**Re: PCD File No. PPR2329  
The Rock Commerce Center, 1st Review  
Response to Comments**

Please accept this letter on behalf of Central Development, LLC, the applicant for The Rock Commerce Center. We received your comment letter dated November 9, 2023, regarding the application and we offer the following responses:

**THE ROCK COMMERCE CENTER
 SITE DEVELOPMENT PLAN
 OVERALL SITE PLAN**

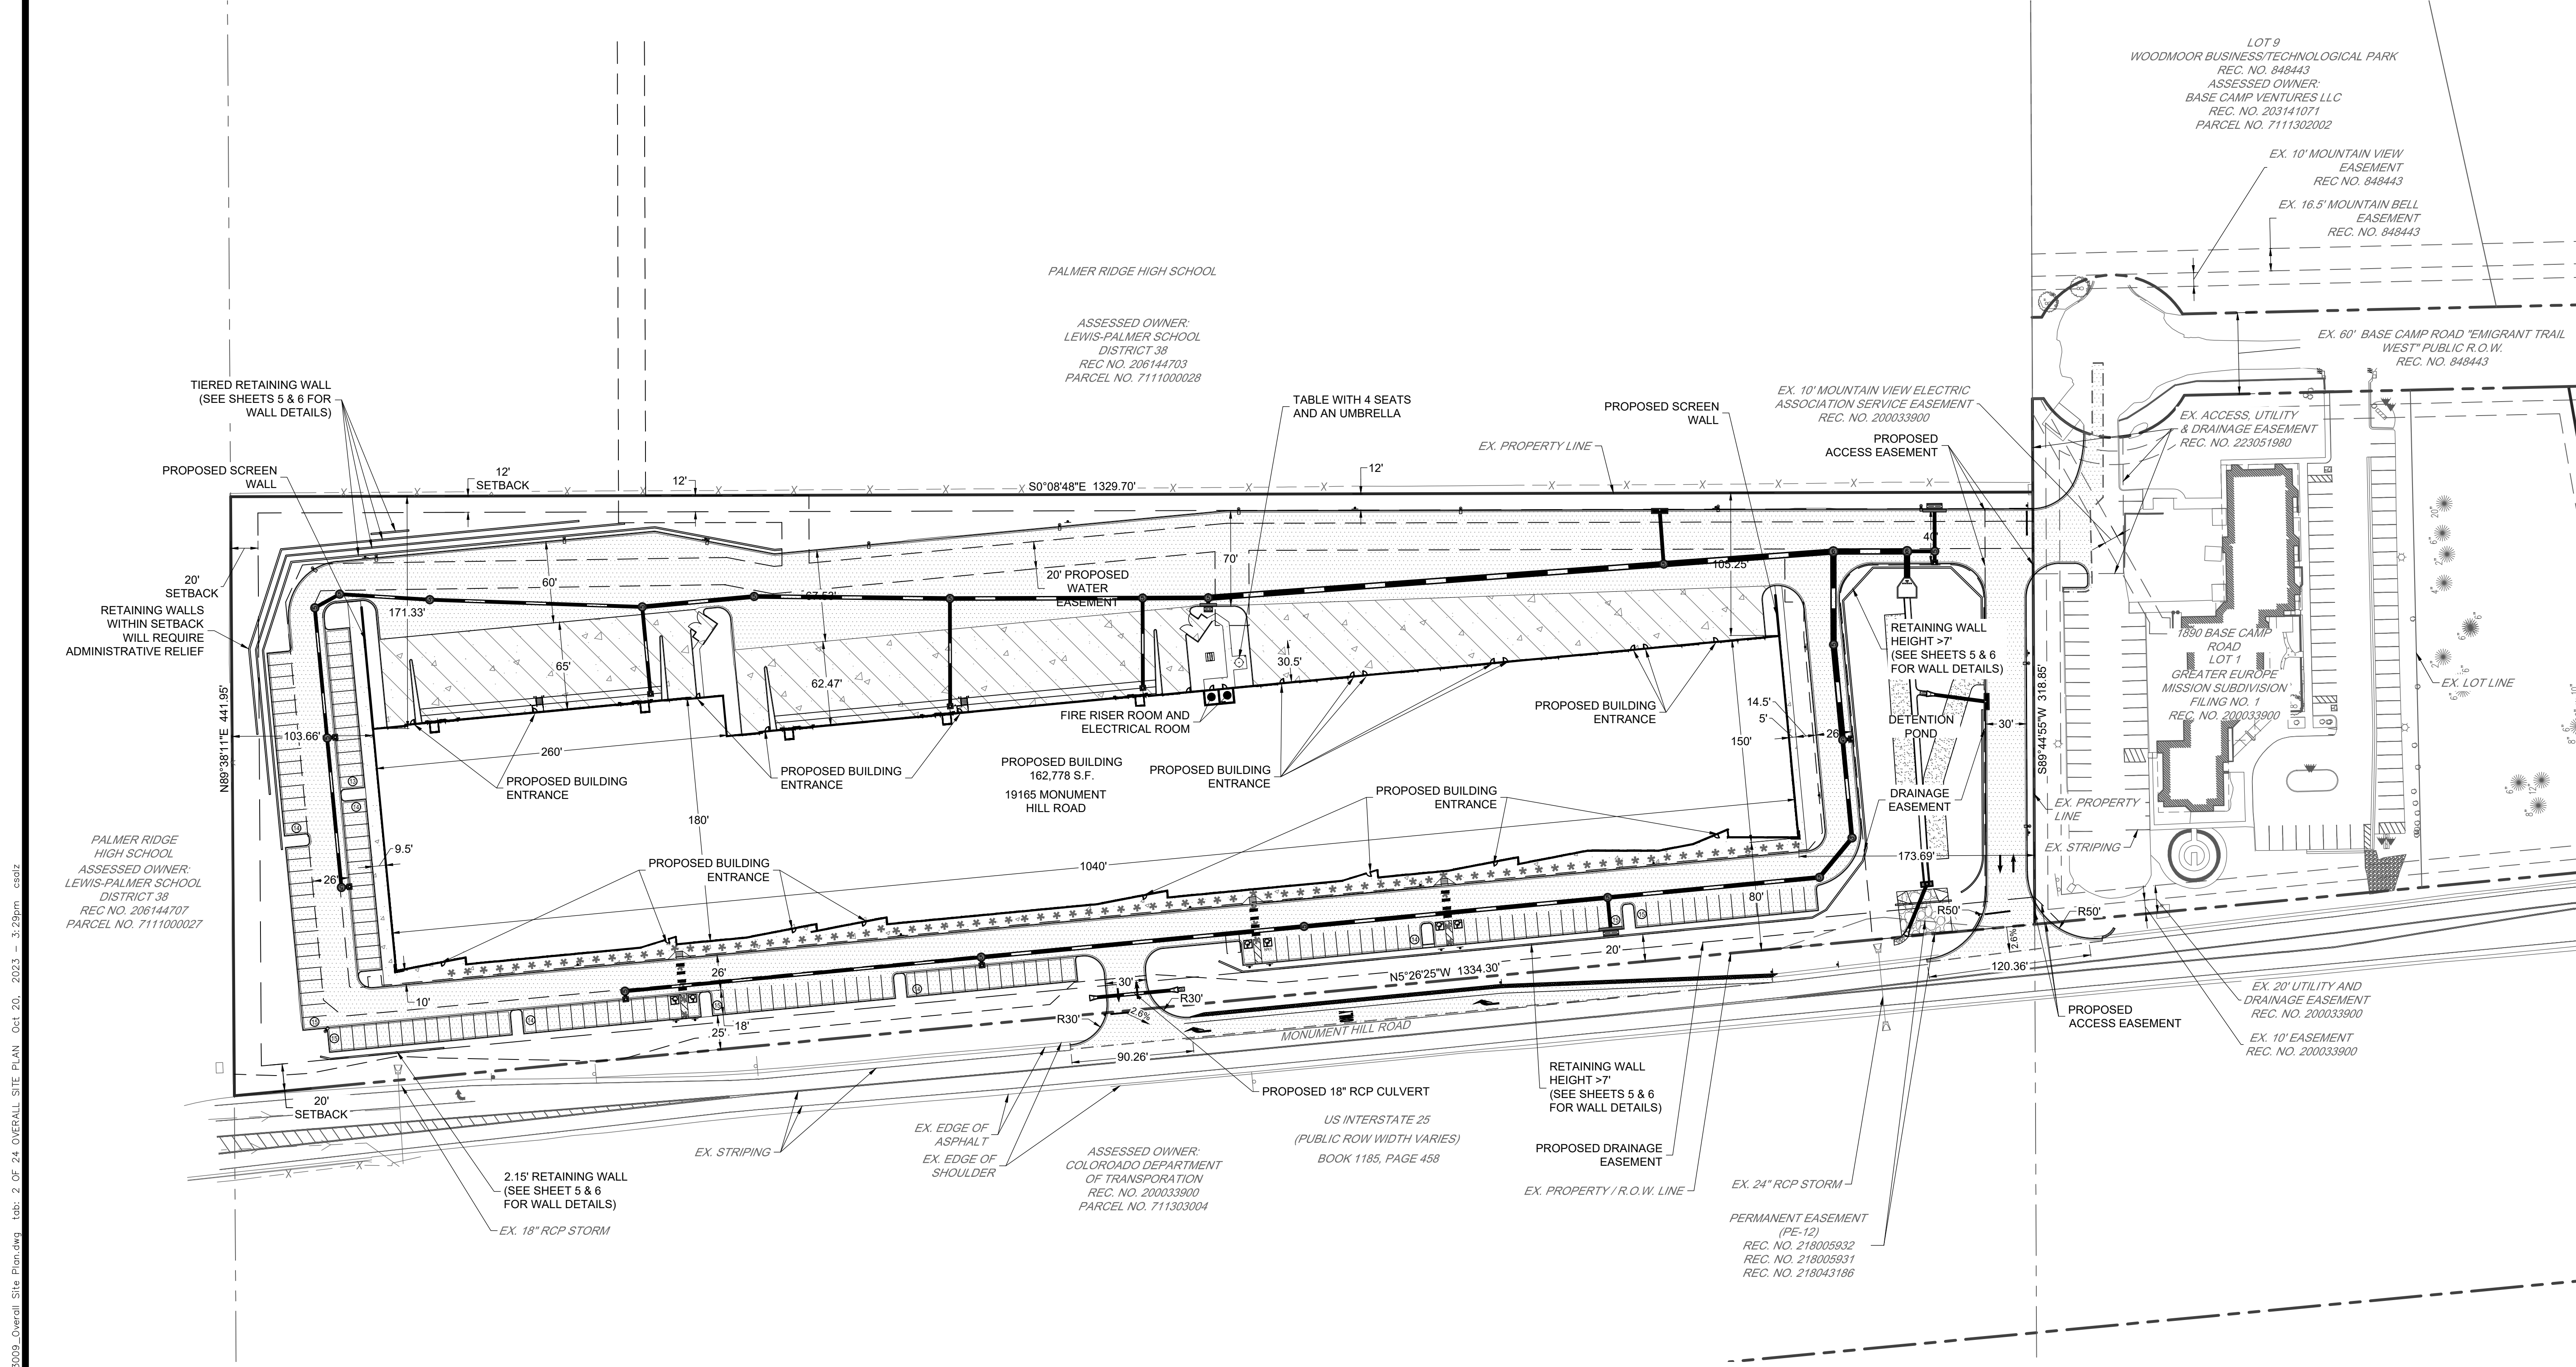
1. *Show traffic circulation arrows.*

2. *Label access width.*

3. *Please see comments on the Traffic Impact Study regarding access spacing. ECM Chapter 2 Table 2-35 access spacing is not met. Please revise access locations to meet criteria.*

5. Consider requesting Alternative Parking Ratio (Section 6.25.D.vi). If you can meet those standards, a modified parking ratio of 1 per 1,200 sqft for Warehouse & Distribution would result in a total required parking of 150 spaces. Easier than processing and paying for a separate Admin Relief Application.

**Response:** Traffic circulation arrows were added throughout the Site Plan as requested.

**Response:** The width of the access to Base Camp Road was labeled on the plan as requested.

**Response:** The appropriate design vehicle for the south access is a single unit truck per the guidance in the ECM and anticipated truck traffic at the site. Access spacing as designed exceeds the requirement for a single unit truck design vehicle on a 45-mph road. Design vehicle and access spacing discussion has been added to the TIS. Figure 2 has been updated with access spacing distances on site and to adjacent access.

**Response:** We will request an Alternative Parking Ratio to change the warehouse parking requirement to 1 space per 1,200 SF from 1 space per 1,000 SF. The number of accessible spaces will remain the same to follow the original intent of the code.

**THE ROCK COMMERCE CENTER
SITE DEVELOPMENT PLAN
SITE PLAN**

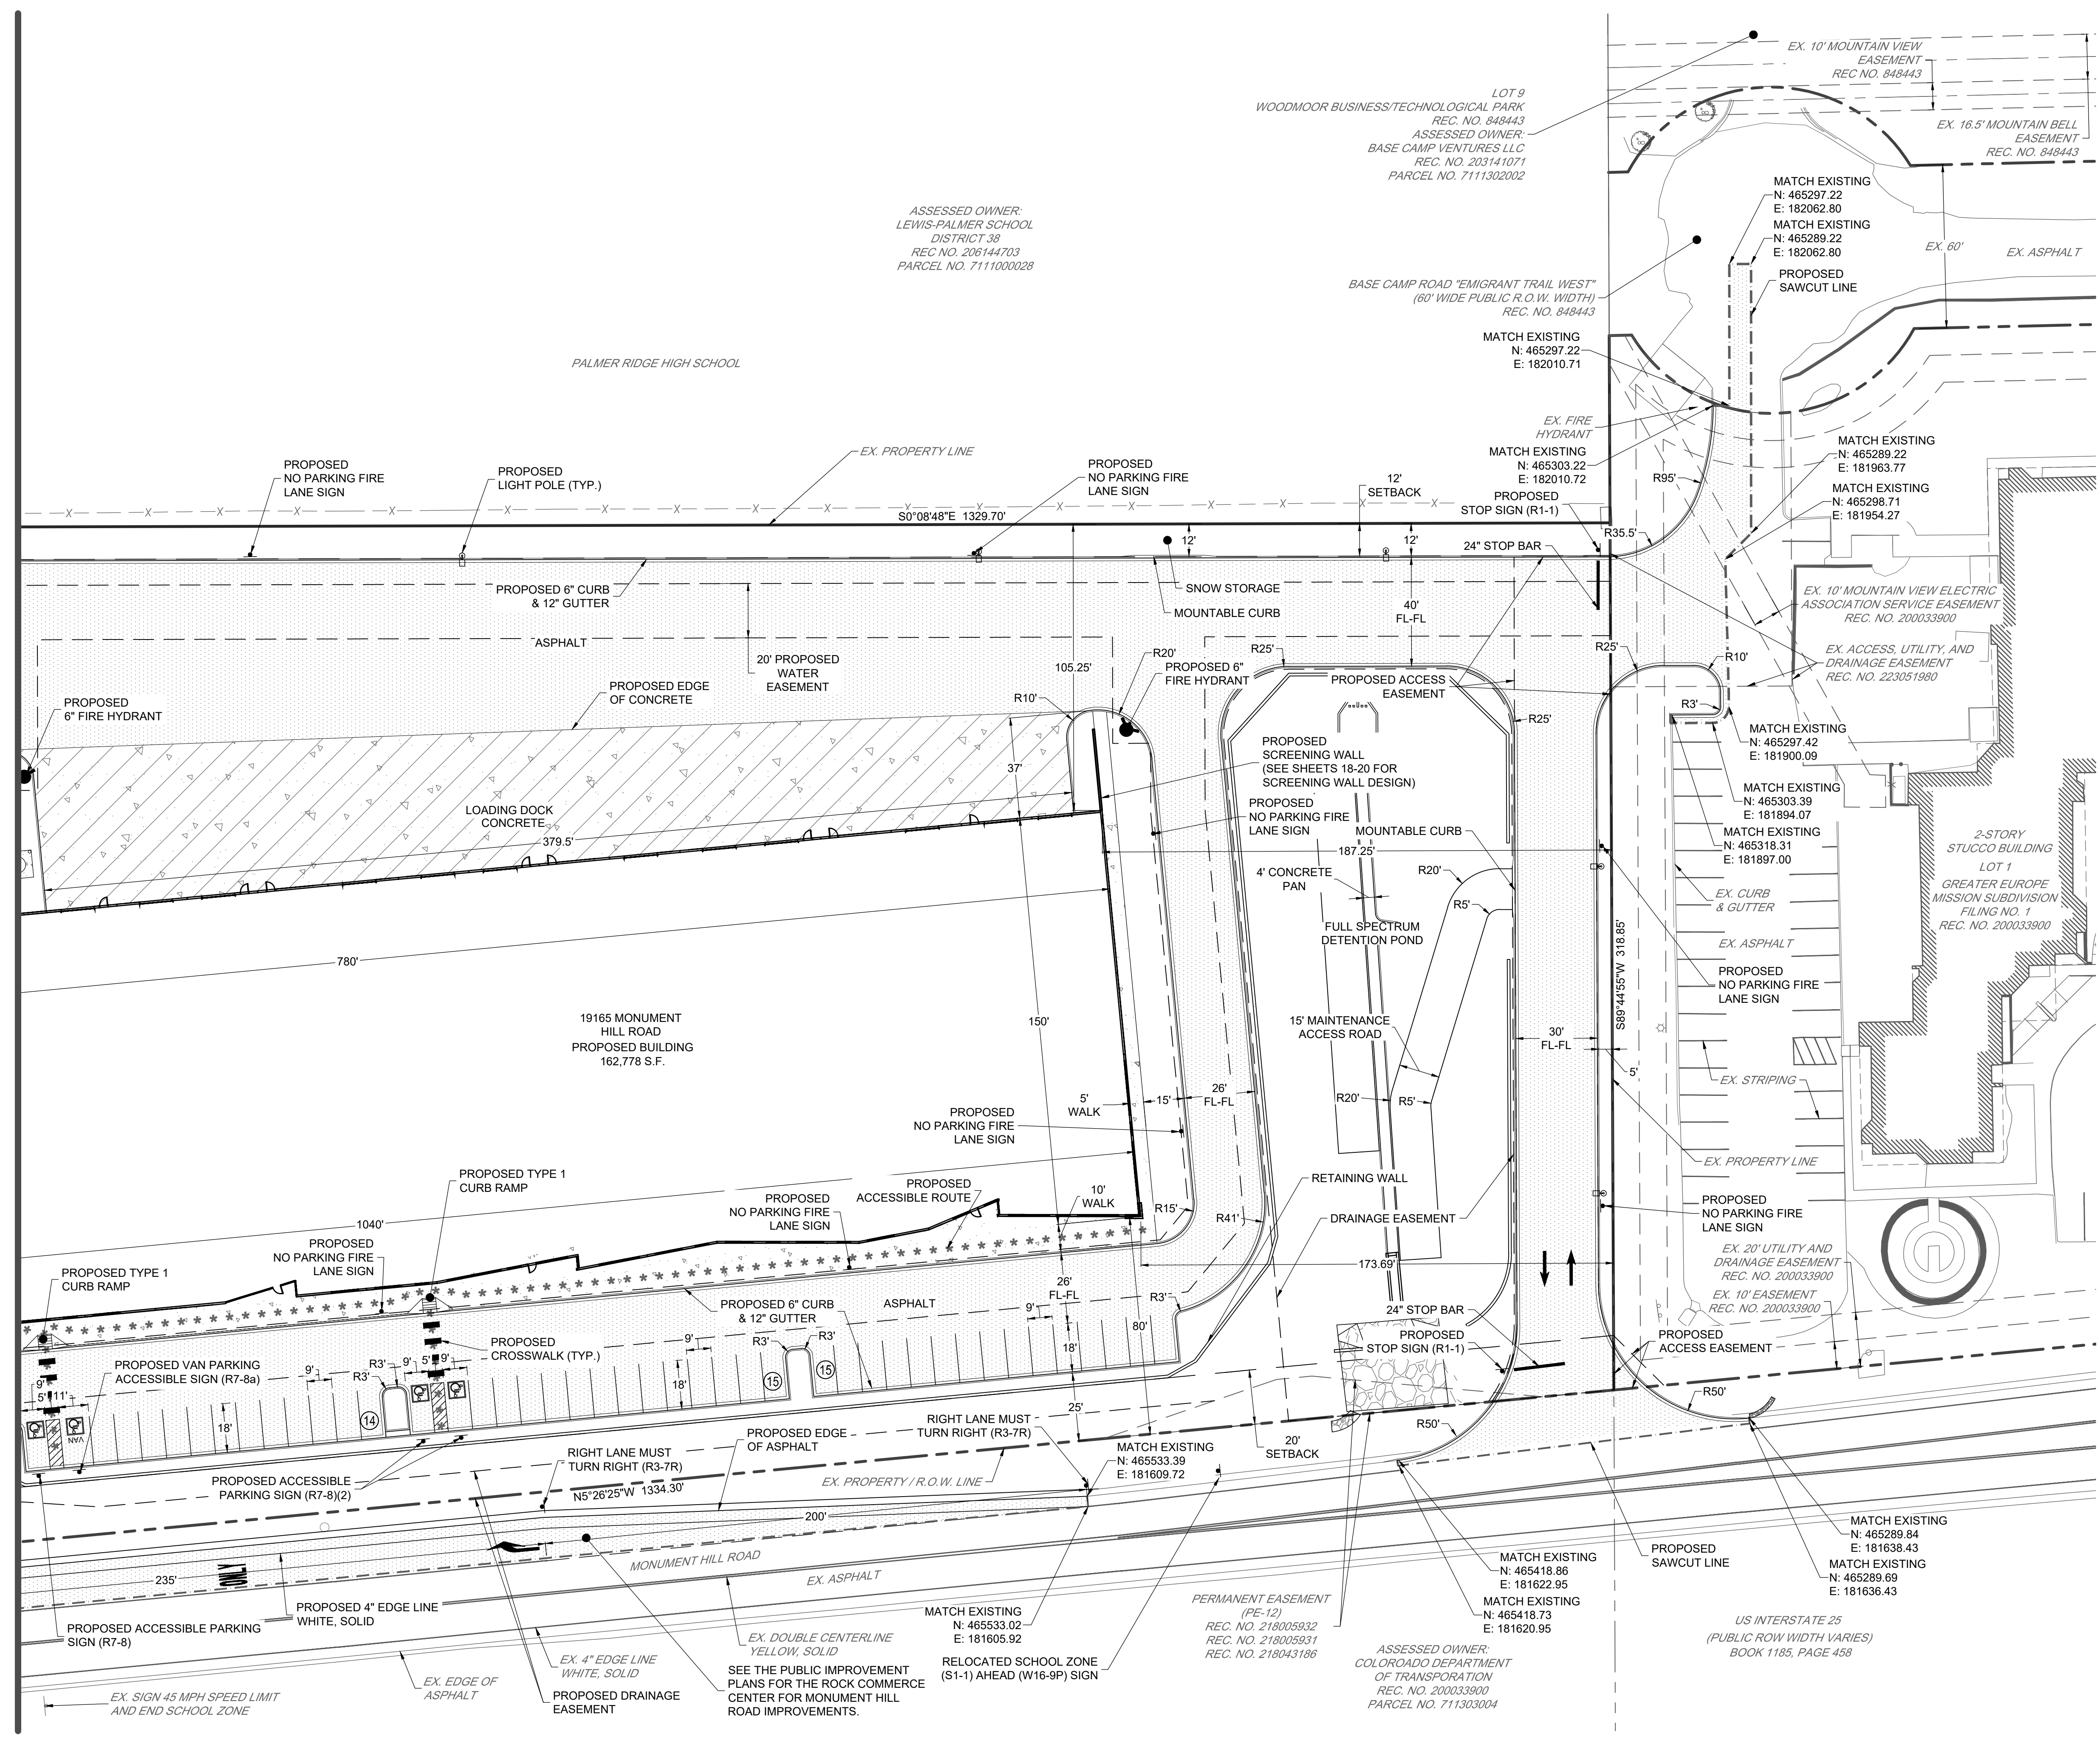
6. Show and label culvert under proposed access drive.

**Response:** The culvert under the proposed access drive is now shown and labeled as requested.
